NORWICH TO TILBURY

EN020027

Comments on Submissions received at Deadline 6

Suffolk County Council

Title:
Figure 11.4 - Historic Environment -
Phase 1 and 2 Geophysical Survey Areas
and Archaeological Trial Trenching
Priority Areas
Page 11 of 24

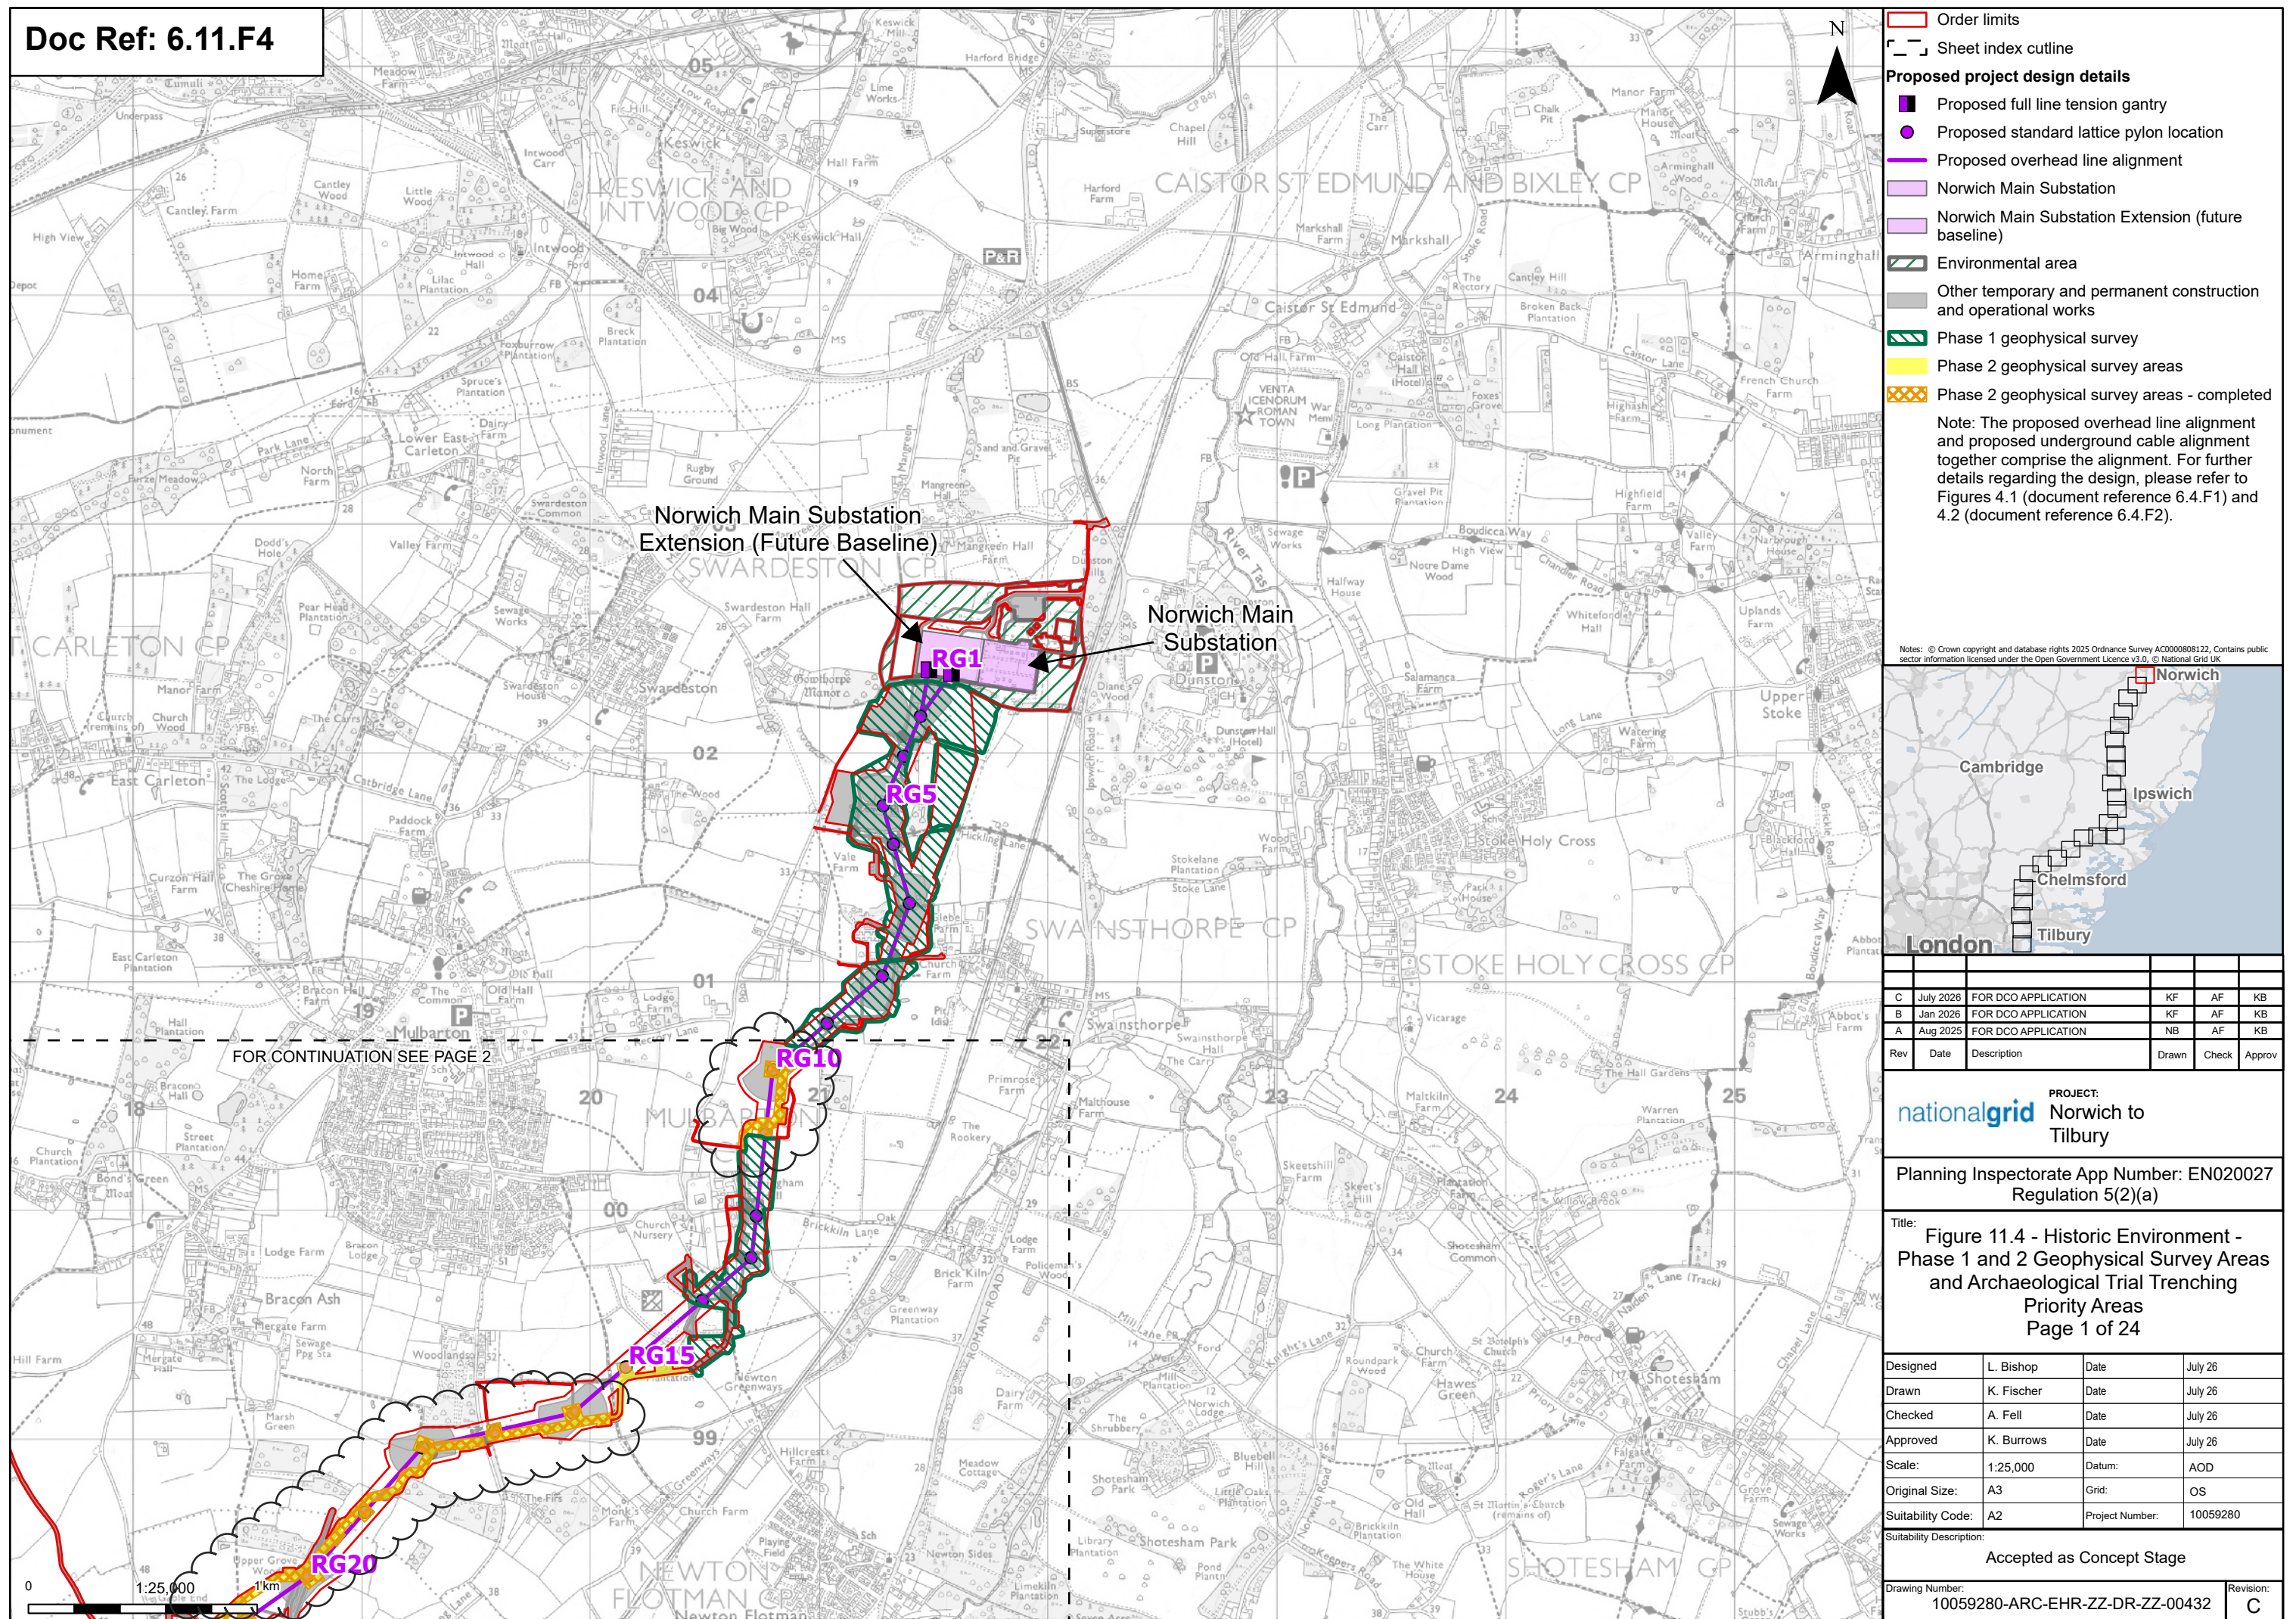
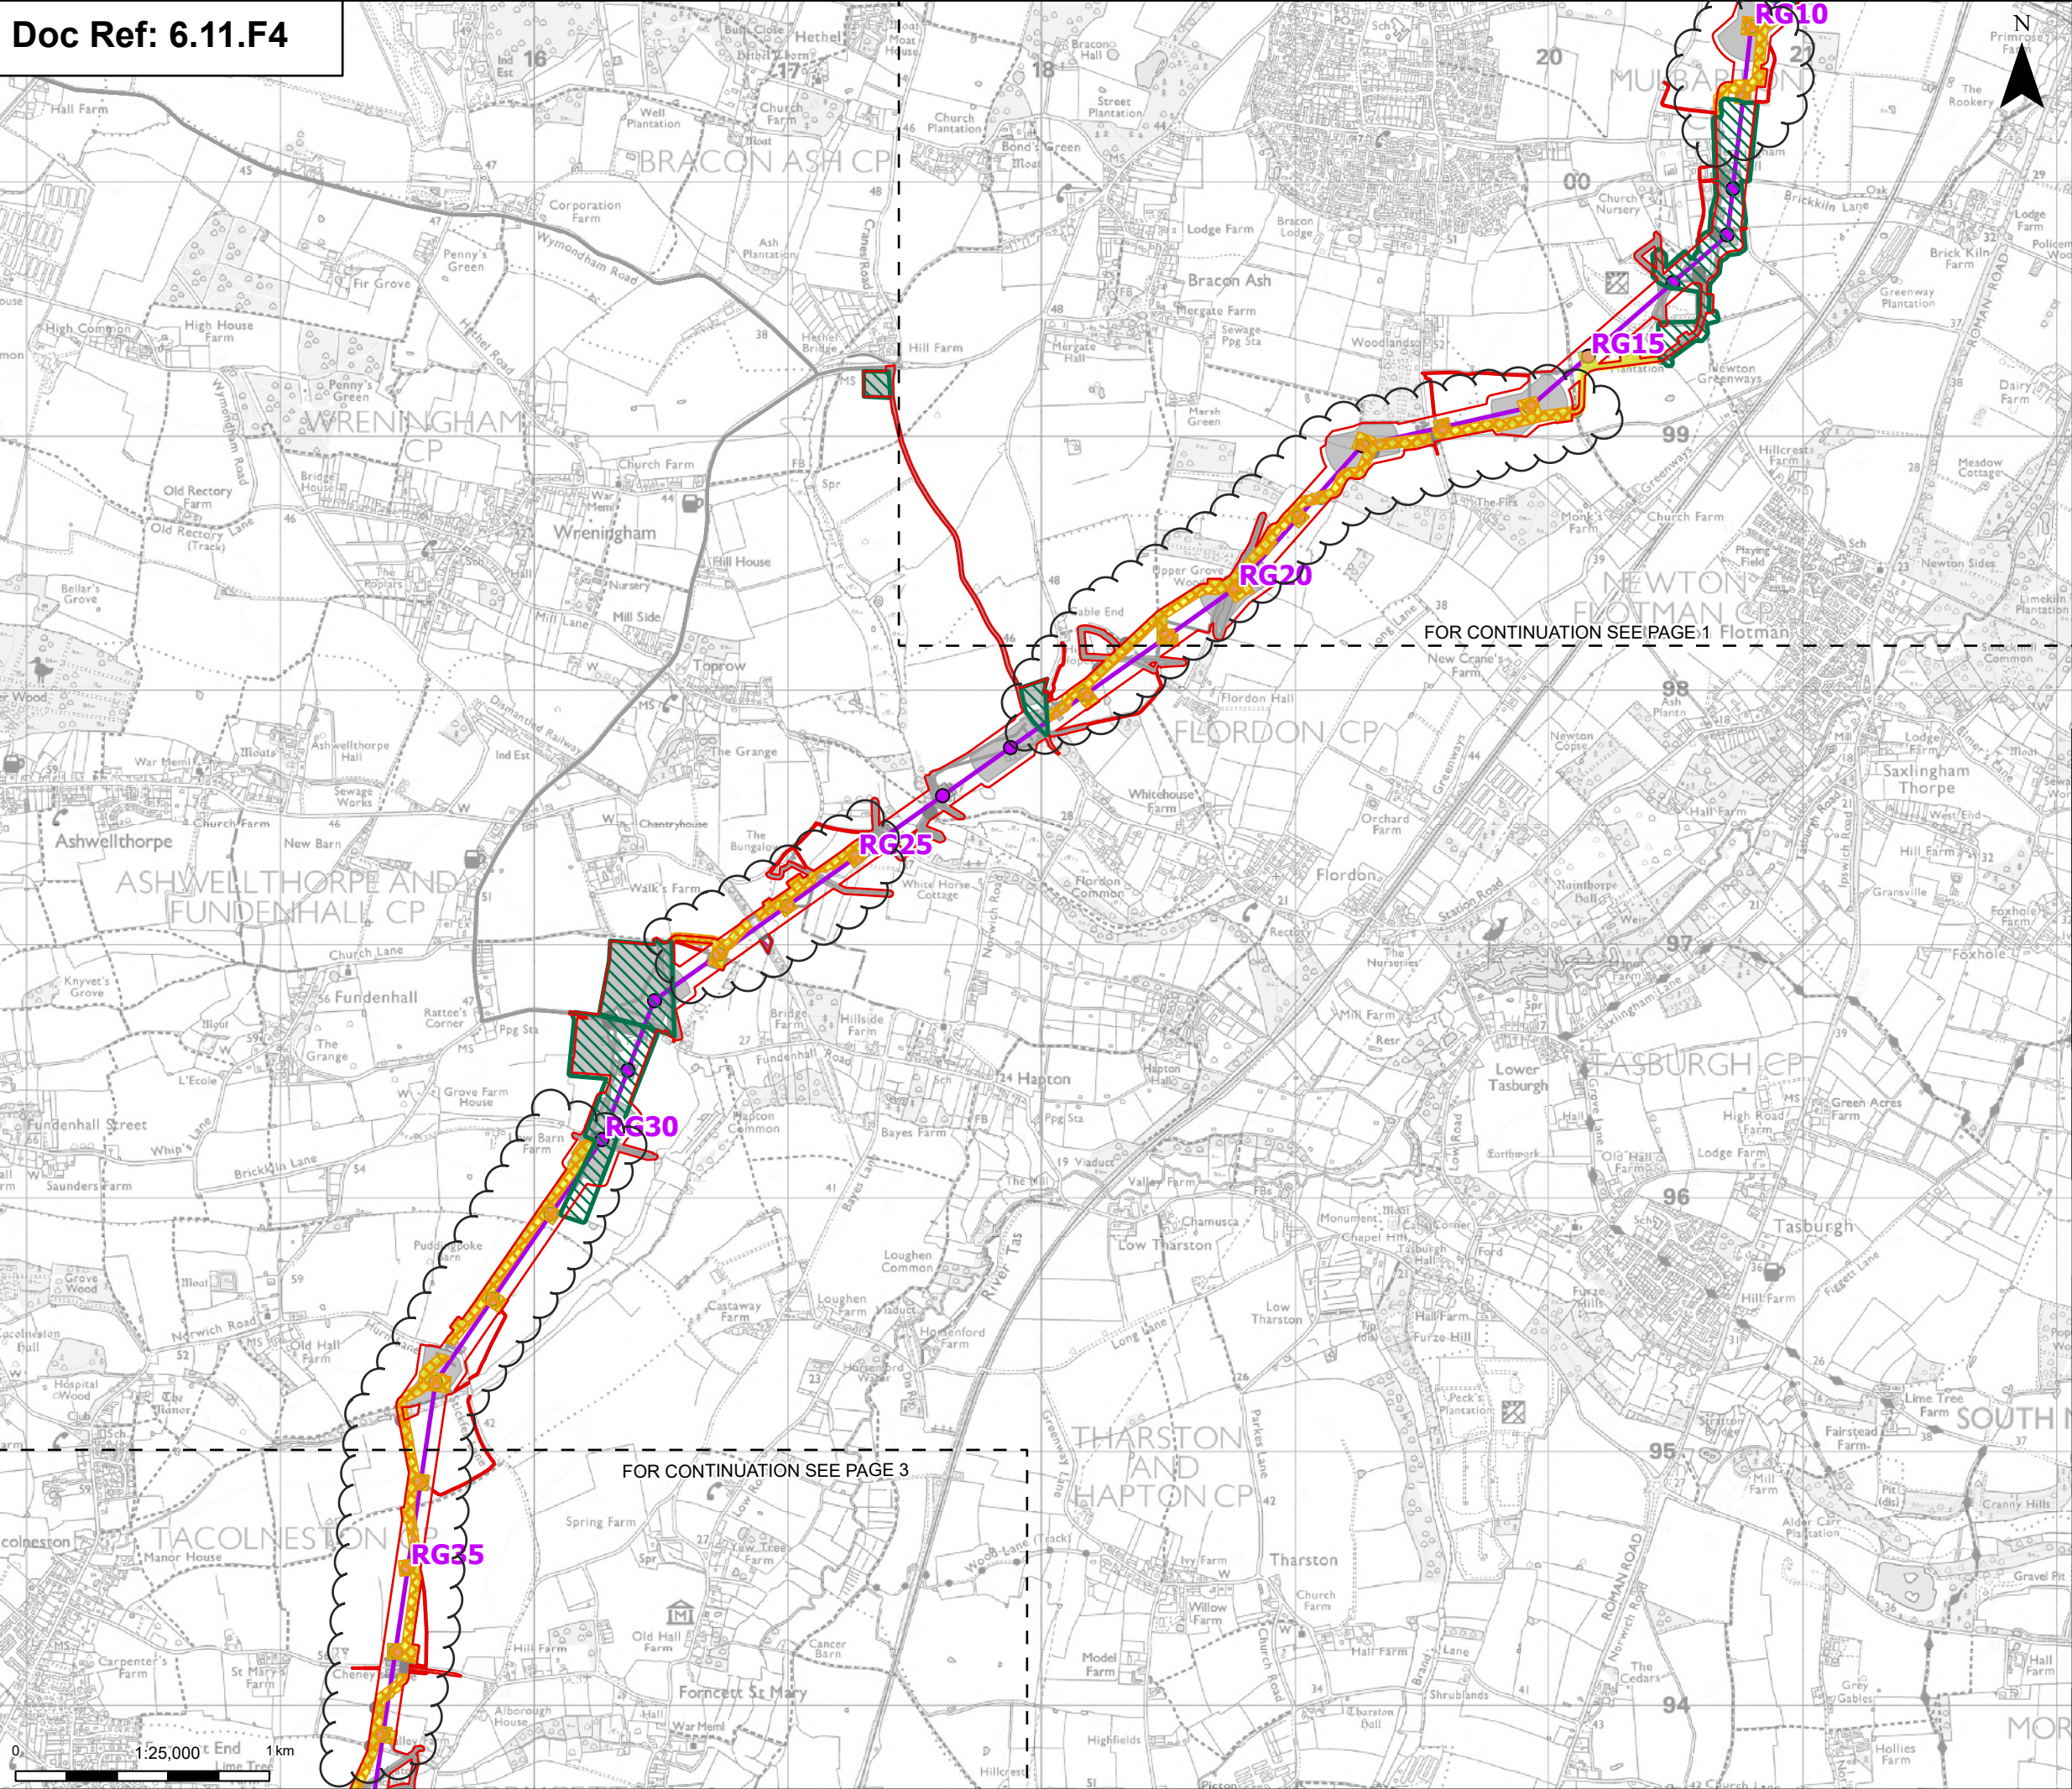
Table 4: 6.11.F4 (C) Phase 1 and 2 Geophysical Survey Areas and Archaeological Trial Trenching Priority Areas [REP6-069]			
Table Item	Service Area and/or Topic	Referenced Paragraph or Item	SCC's Comments

4.1	Archaeology	General Comment	This plan identifies the areas that have undergone priority evaluation, including priority geophysical survey and trial trenching. It also shows those areas where Phase 2 geophysical survey has been undertaken. SCCAS welcomes the submission of this plan as part of the Examination. Document 6.11.A8 Environmental Statement Appendix 11.8 – Phase 2 Geophysical Survey [REP6-065] states that approximately 86% of the Phase 2 area has been subject to geophysical survey. Figures in 6.11.F4 Phase 1 and 2 Geophysical Survey Areas and Archaeological Trial Trenching Priority Areas [REP6-069] indicate the unsurveyed areas, the applicant should state when these remaining areas will be surveyed or, where survey is not possible, how they will be archaeologically evaluated.
